City of Albuquerque  
Planning Department  
Development Services Division  
P.O. Box 1293  
Albuquerque, New Mexico 87103

**OFFICIAL NOTIFICATION OF DECISION**

FILE: Z-99-115  
LEGAL DESCRIPTION: For Tract B-1,  
Cottonwood Corners, zoned SU-1 for IP,  
located on NM 528, between Coors Boulevard  
Bypass NW and Ellison Drive, containing  
approximately 28.8 acres. (A-13 & A-14) Bob  
Torres, Staff Planner (CONTINUED FROM  
OCTOBER 21, 1999)

On November 18, 1999, the Environmental Planning Commission voted to approve Z-99-115, a site plan for subdivision based on the following Findings and subject to the following Conditions:

SITE DEVELOPMENT PLAN

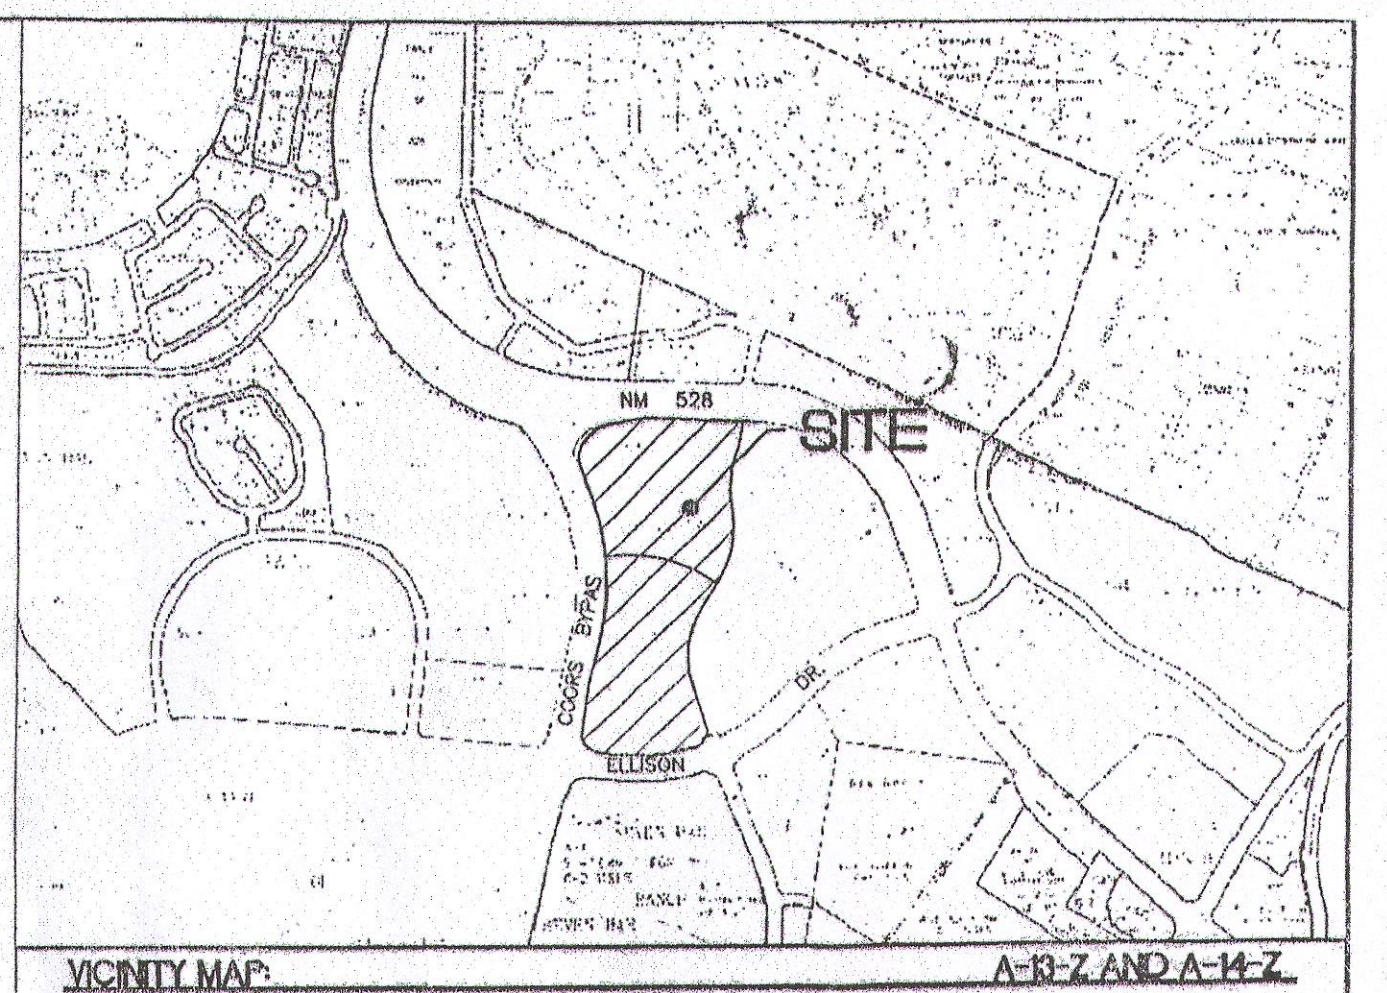
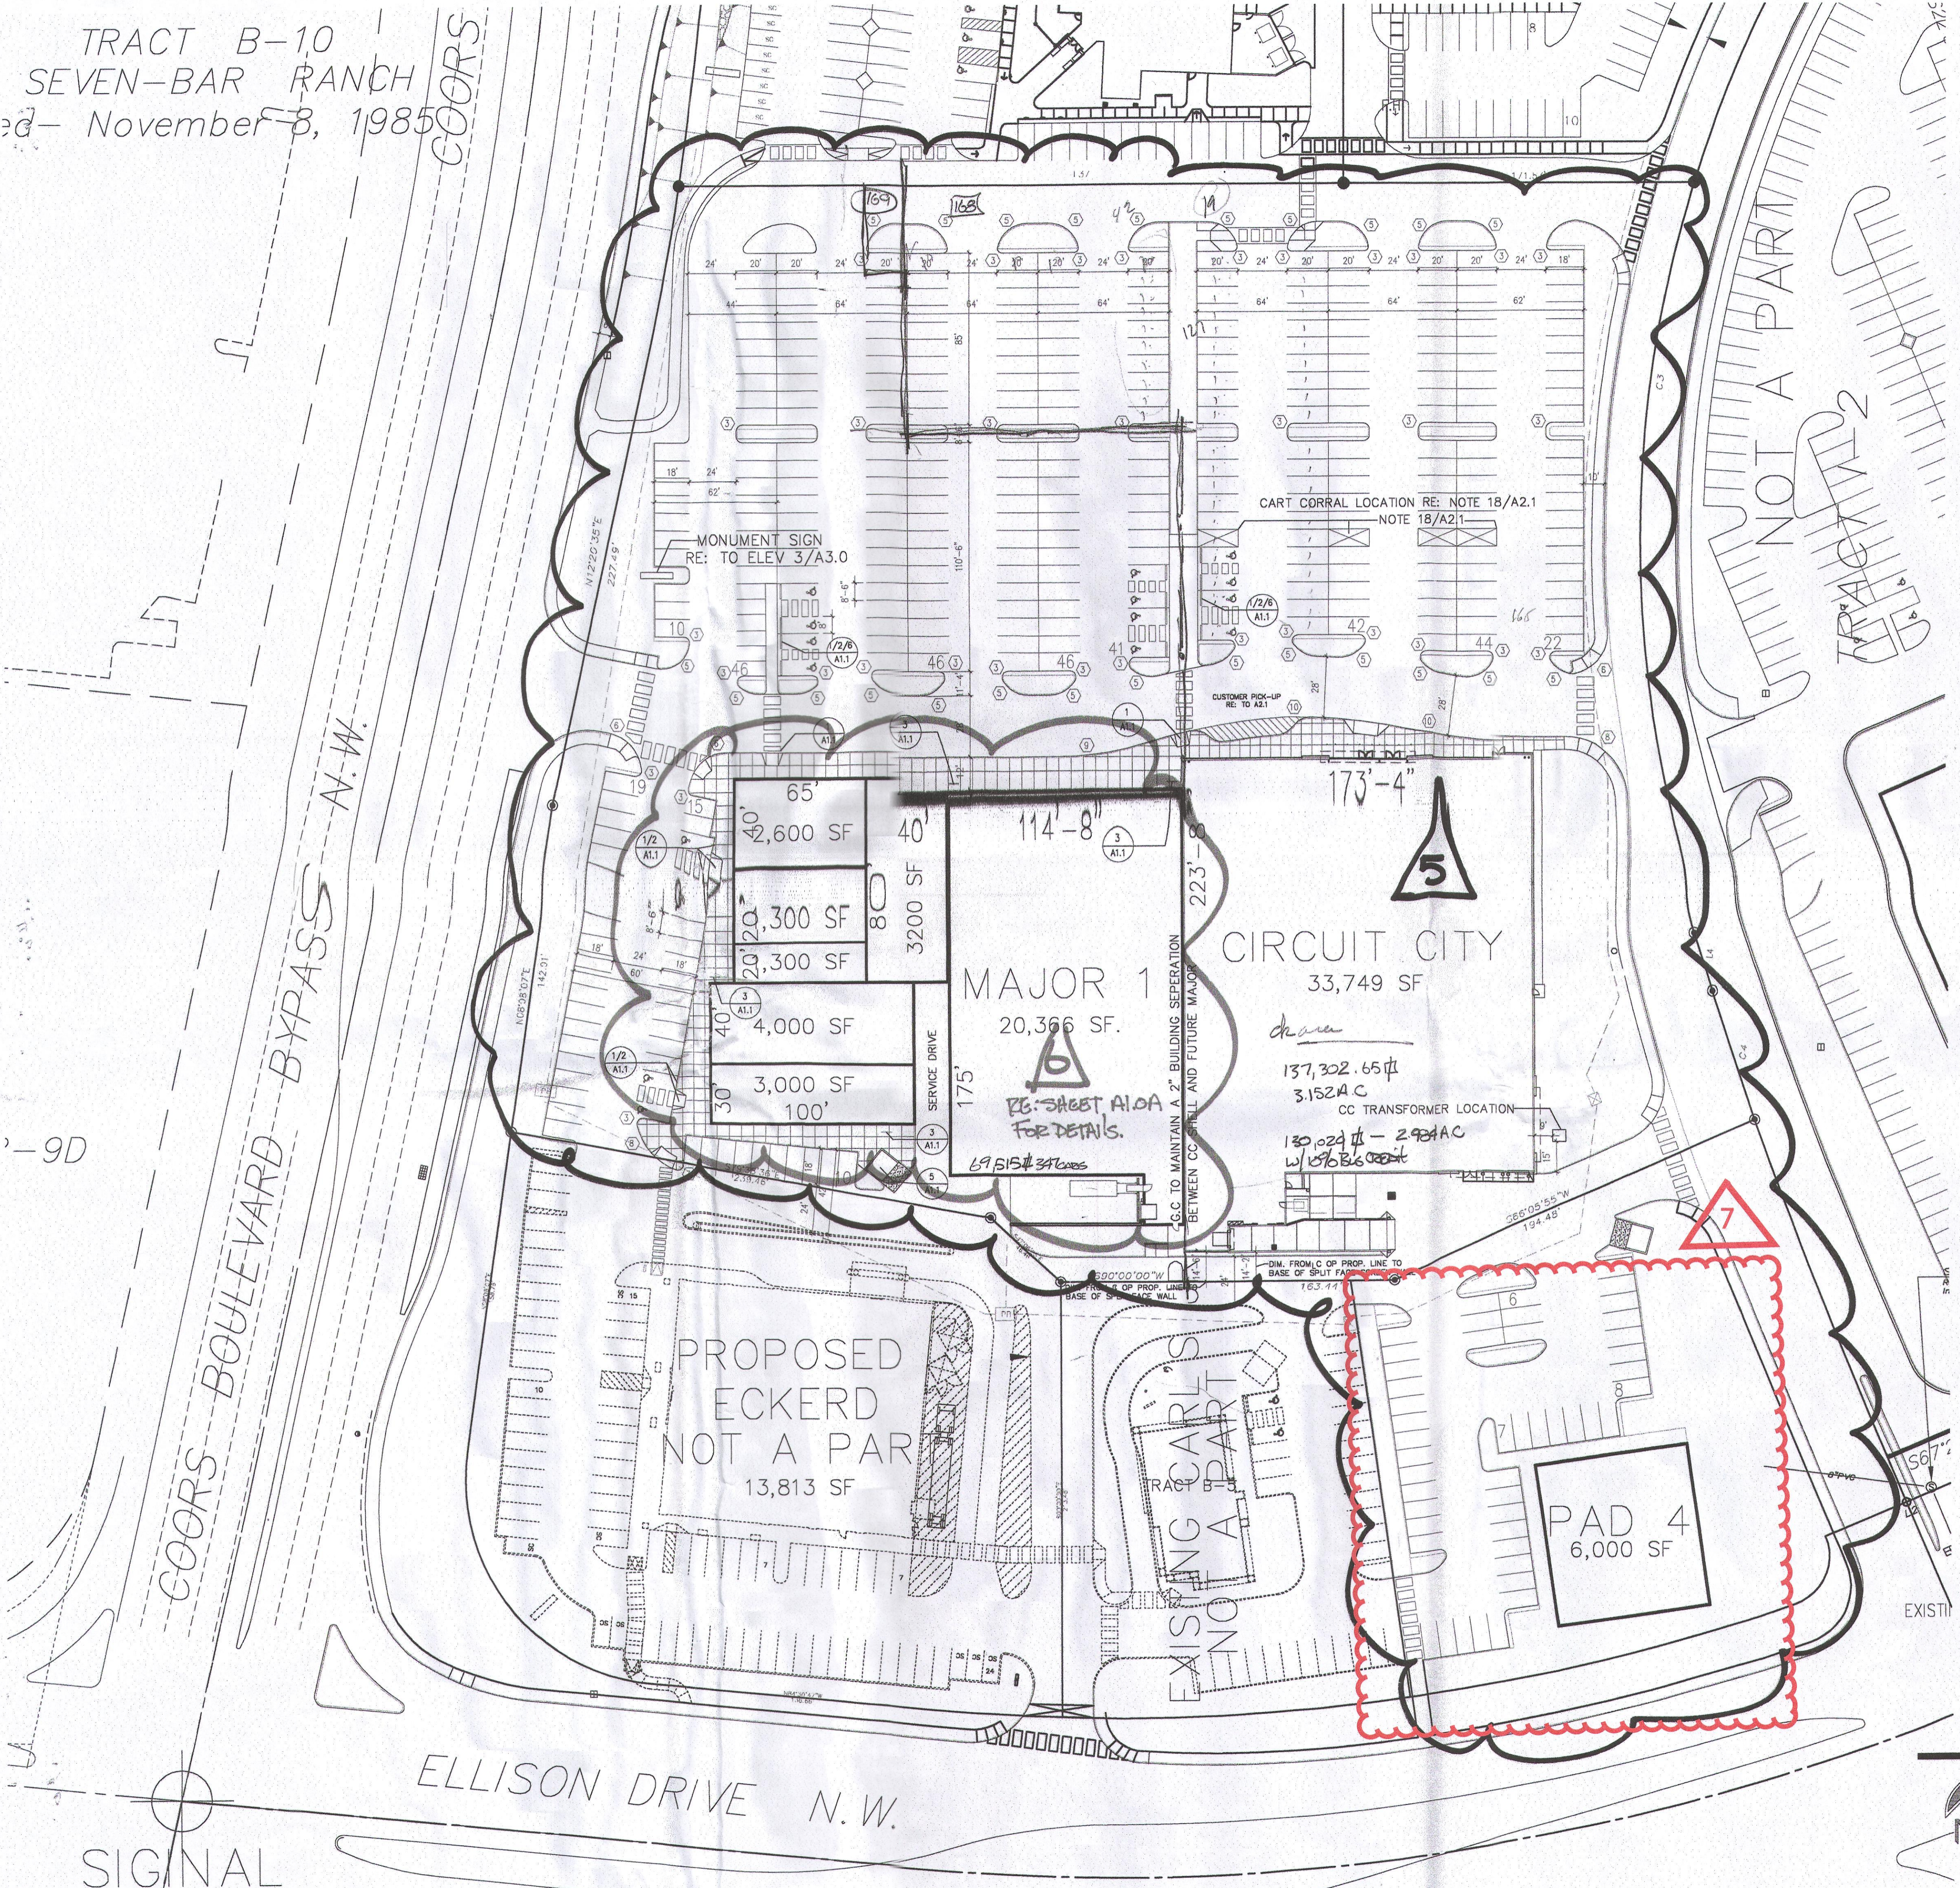
7. The site is located within the Regional Center boundaries designated by the *West Side Strategic Plan.*
8. The landscaping islands and tree location requirements do not meet the minimum city standards. The general site landscaping is minimal.

9. The site plan shows the majority, 14 out of the 16 ADA parking spaces, using drive aisles as the only access to the building to the parking area this creates a safety hazard.

10. No plaza is indicated on the plan. The Westside Strategic Plan recommends plazas for new development.
11. Pedestrian oriented provisions are marginal.

12. There is a surplus of 19 parking spaces shown on the site and there is a potential of utilizing bus line credits available up to 10% of parking.
13. NM528 and multi storey apartment buildings overlook the site from the west.

14. The sidewalk at the main entry areas scales in some locations as 3 feet clear and 5 feet clear.
15. All drive aisles are shown at 25 feet.
16. The ornamental fence is not indicated on the plans.

17. There are no provisions for bike lockers or showers indicated.
18. There is no employee patio or break area indicated.
19. The building is a relatively flat unarticulated box like building. The front elevation has 285 foot long flat wall. The east side of the building has 160 foot flat wall, and 140 foot flat wall. The north side of the building has a 390 foot unarticulated flat like wall.

20. Approximately 2% of the total surface elevation area is glazing.
21. Portals are indicated on the elevation on the southeast corner but is not indicated on the plan.

22. A pedestrian pathway and ADA access is located at a vehicle stop.

- A. The sidewalk at the entrance side of all buildings shall be 15' wide with shade trees 25' apart on 5'x5' inside dimension planters.
  - B. Protect pedestrian paths with bollards or by raising the pedestrian walk 6" above the paving where there is angled or perpendicular parking adjacent. Raised paths should be 8' wide where there is parking on one side, 10' wide if there is parking adjacent on both sides.

- C. Where pedestrian paths are parallel to adjacent parking, there shall be a 5' landscape island between the path and parking, except for ADA spaces.

- D. Where pedestrian paths cross vehicular circulation, pedestrian paths shall be minimum 6' wide and clearly demarcated with slightly raised alternative textured material.

- E. Add pedestrian paths between this development and the development to the east across Cottonwood Drive. Locate paths on both sides of driveway intersections with Cottonwood Drive.

5. The top of rooftop equipment shall be below parapet height. The transformer and trash compactor should be screened with a screenwall. The top of the screenwall shall be taller than top of equipment.

8. Street trees shall be provided at the rate of one tree every 30' and shall be a mix of deciduous and evergreen. Street trees shall be added along the north property line at NM 528 at an average of 20 feet on center for screening. The trees shall be a mix of evergreens and deciduous trees.

11. Future development of the gas station will require EPC site plan review.
12. Provide a detail of the bicycle rack. Provide parking capacity for 32 bicycles at Major 1.

13. Provide bike lockers and showers for employees.
14. A plaza area shall be located near the main building entry, the area minimum width shall be 30 feet in width and there shall be a minimum of 1000 square feet on the plaza.

15. All landscaping aisles at end aisles shall be a minimum of 10 feet in width.
16. All ADA parking shall have a clear direct ADA compliant pathway to the entry sidewalk. Drive aisles shall not be utilized as a pathway other than crossing to a sidewalk. All drive aisles crossings shall be compliant to condition 3.

17. All pedestrian ways at the main north/south drive which is the perpendicular access to the building shall be a minimum 8 feet in width (6 feet clear) with 5 x 5 planters adjacent at 25 feet on center and trees.

18. Where any parking areas are indicated a minimum six foot sidewalk continuous shall be provided around the perimeter of the building to provide pedestrian access from parking area to the entry doors. Shade trees shall be provided at 25 feet on center along those walkways and 5 x 5 planters or the option for portals with a minimum 6 foot overhang.

19. The ornamental fence shall be indicated on the plans.
20. Asphalt paving shall be reduced and landscaping and sidewalks shall be added at the electrical transformer area on the west side of the building.

21. Add a minimum of 4 shade trees per row of parking at the south side of the building at a minimum 5 trees per row at the east side of the building and 5 at the west.

22. Add display windows at a minimum 8 foot by 8 foot along the front elevation of building at 30 feet on center.

23. Light standards shall be a maximum of 36 feet in height.
24. No generic franchise pad designs shall be permitted.
25. At the southeast corner of the building add a 10 foot walkway 50 feet north of the corner.
26. Add a shade canopy minimum 8 foot width at the TLE (Tire, Lube and Emissions) above all garage doors.
27. Add a 15 foot wide sidewalk area with shade trees and 5 x 5 planters within the 15 foot dimension at 25 feet on center at the northeast corner of the building to a dimension 100 feet south of that corner.
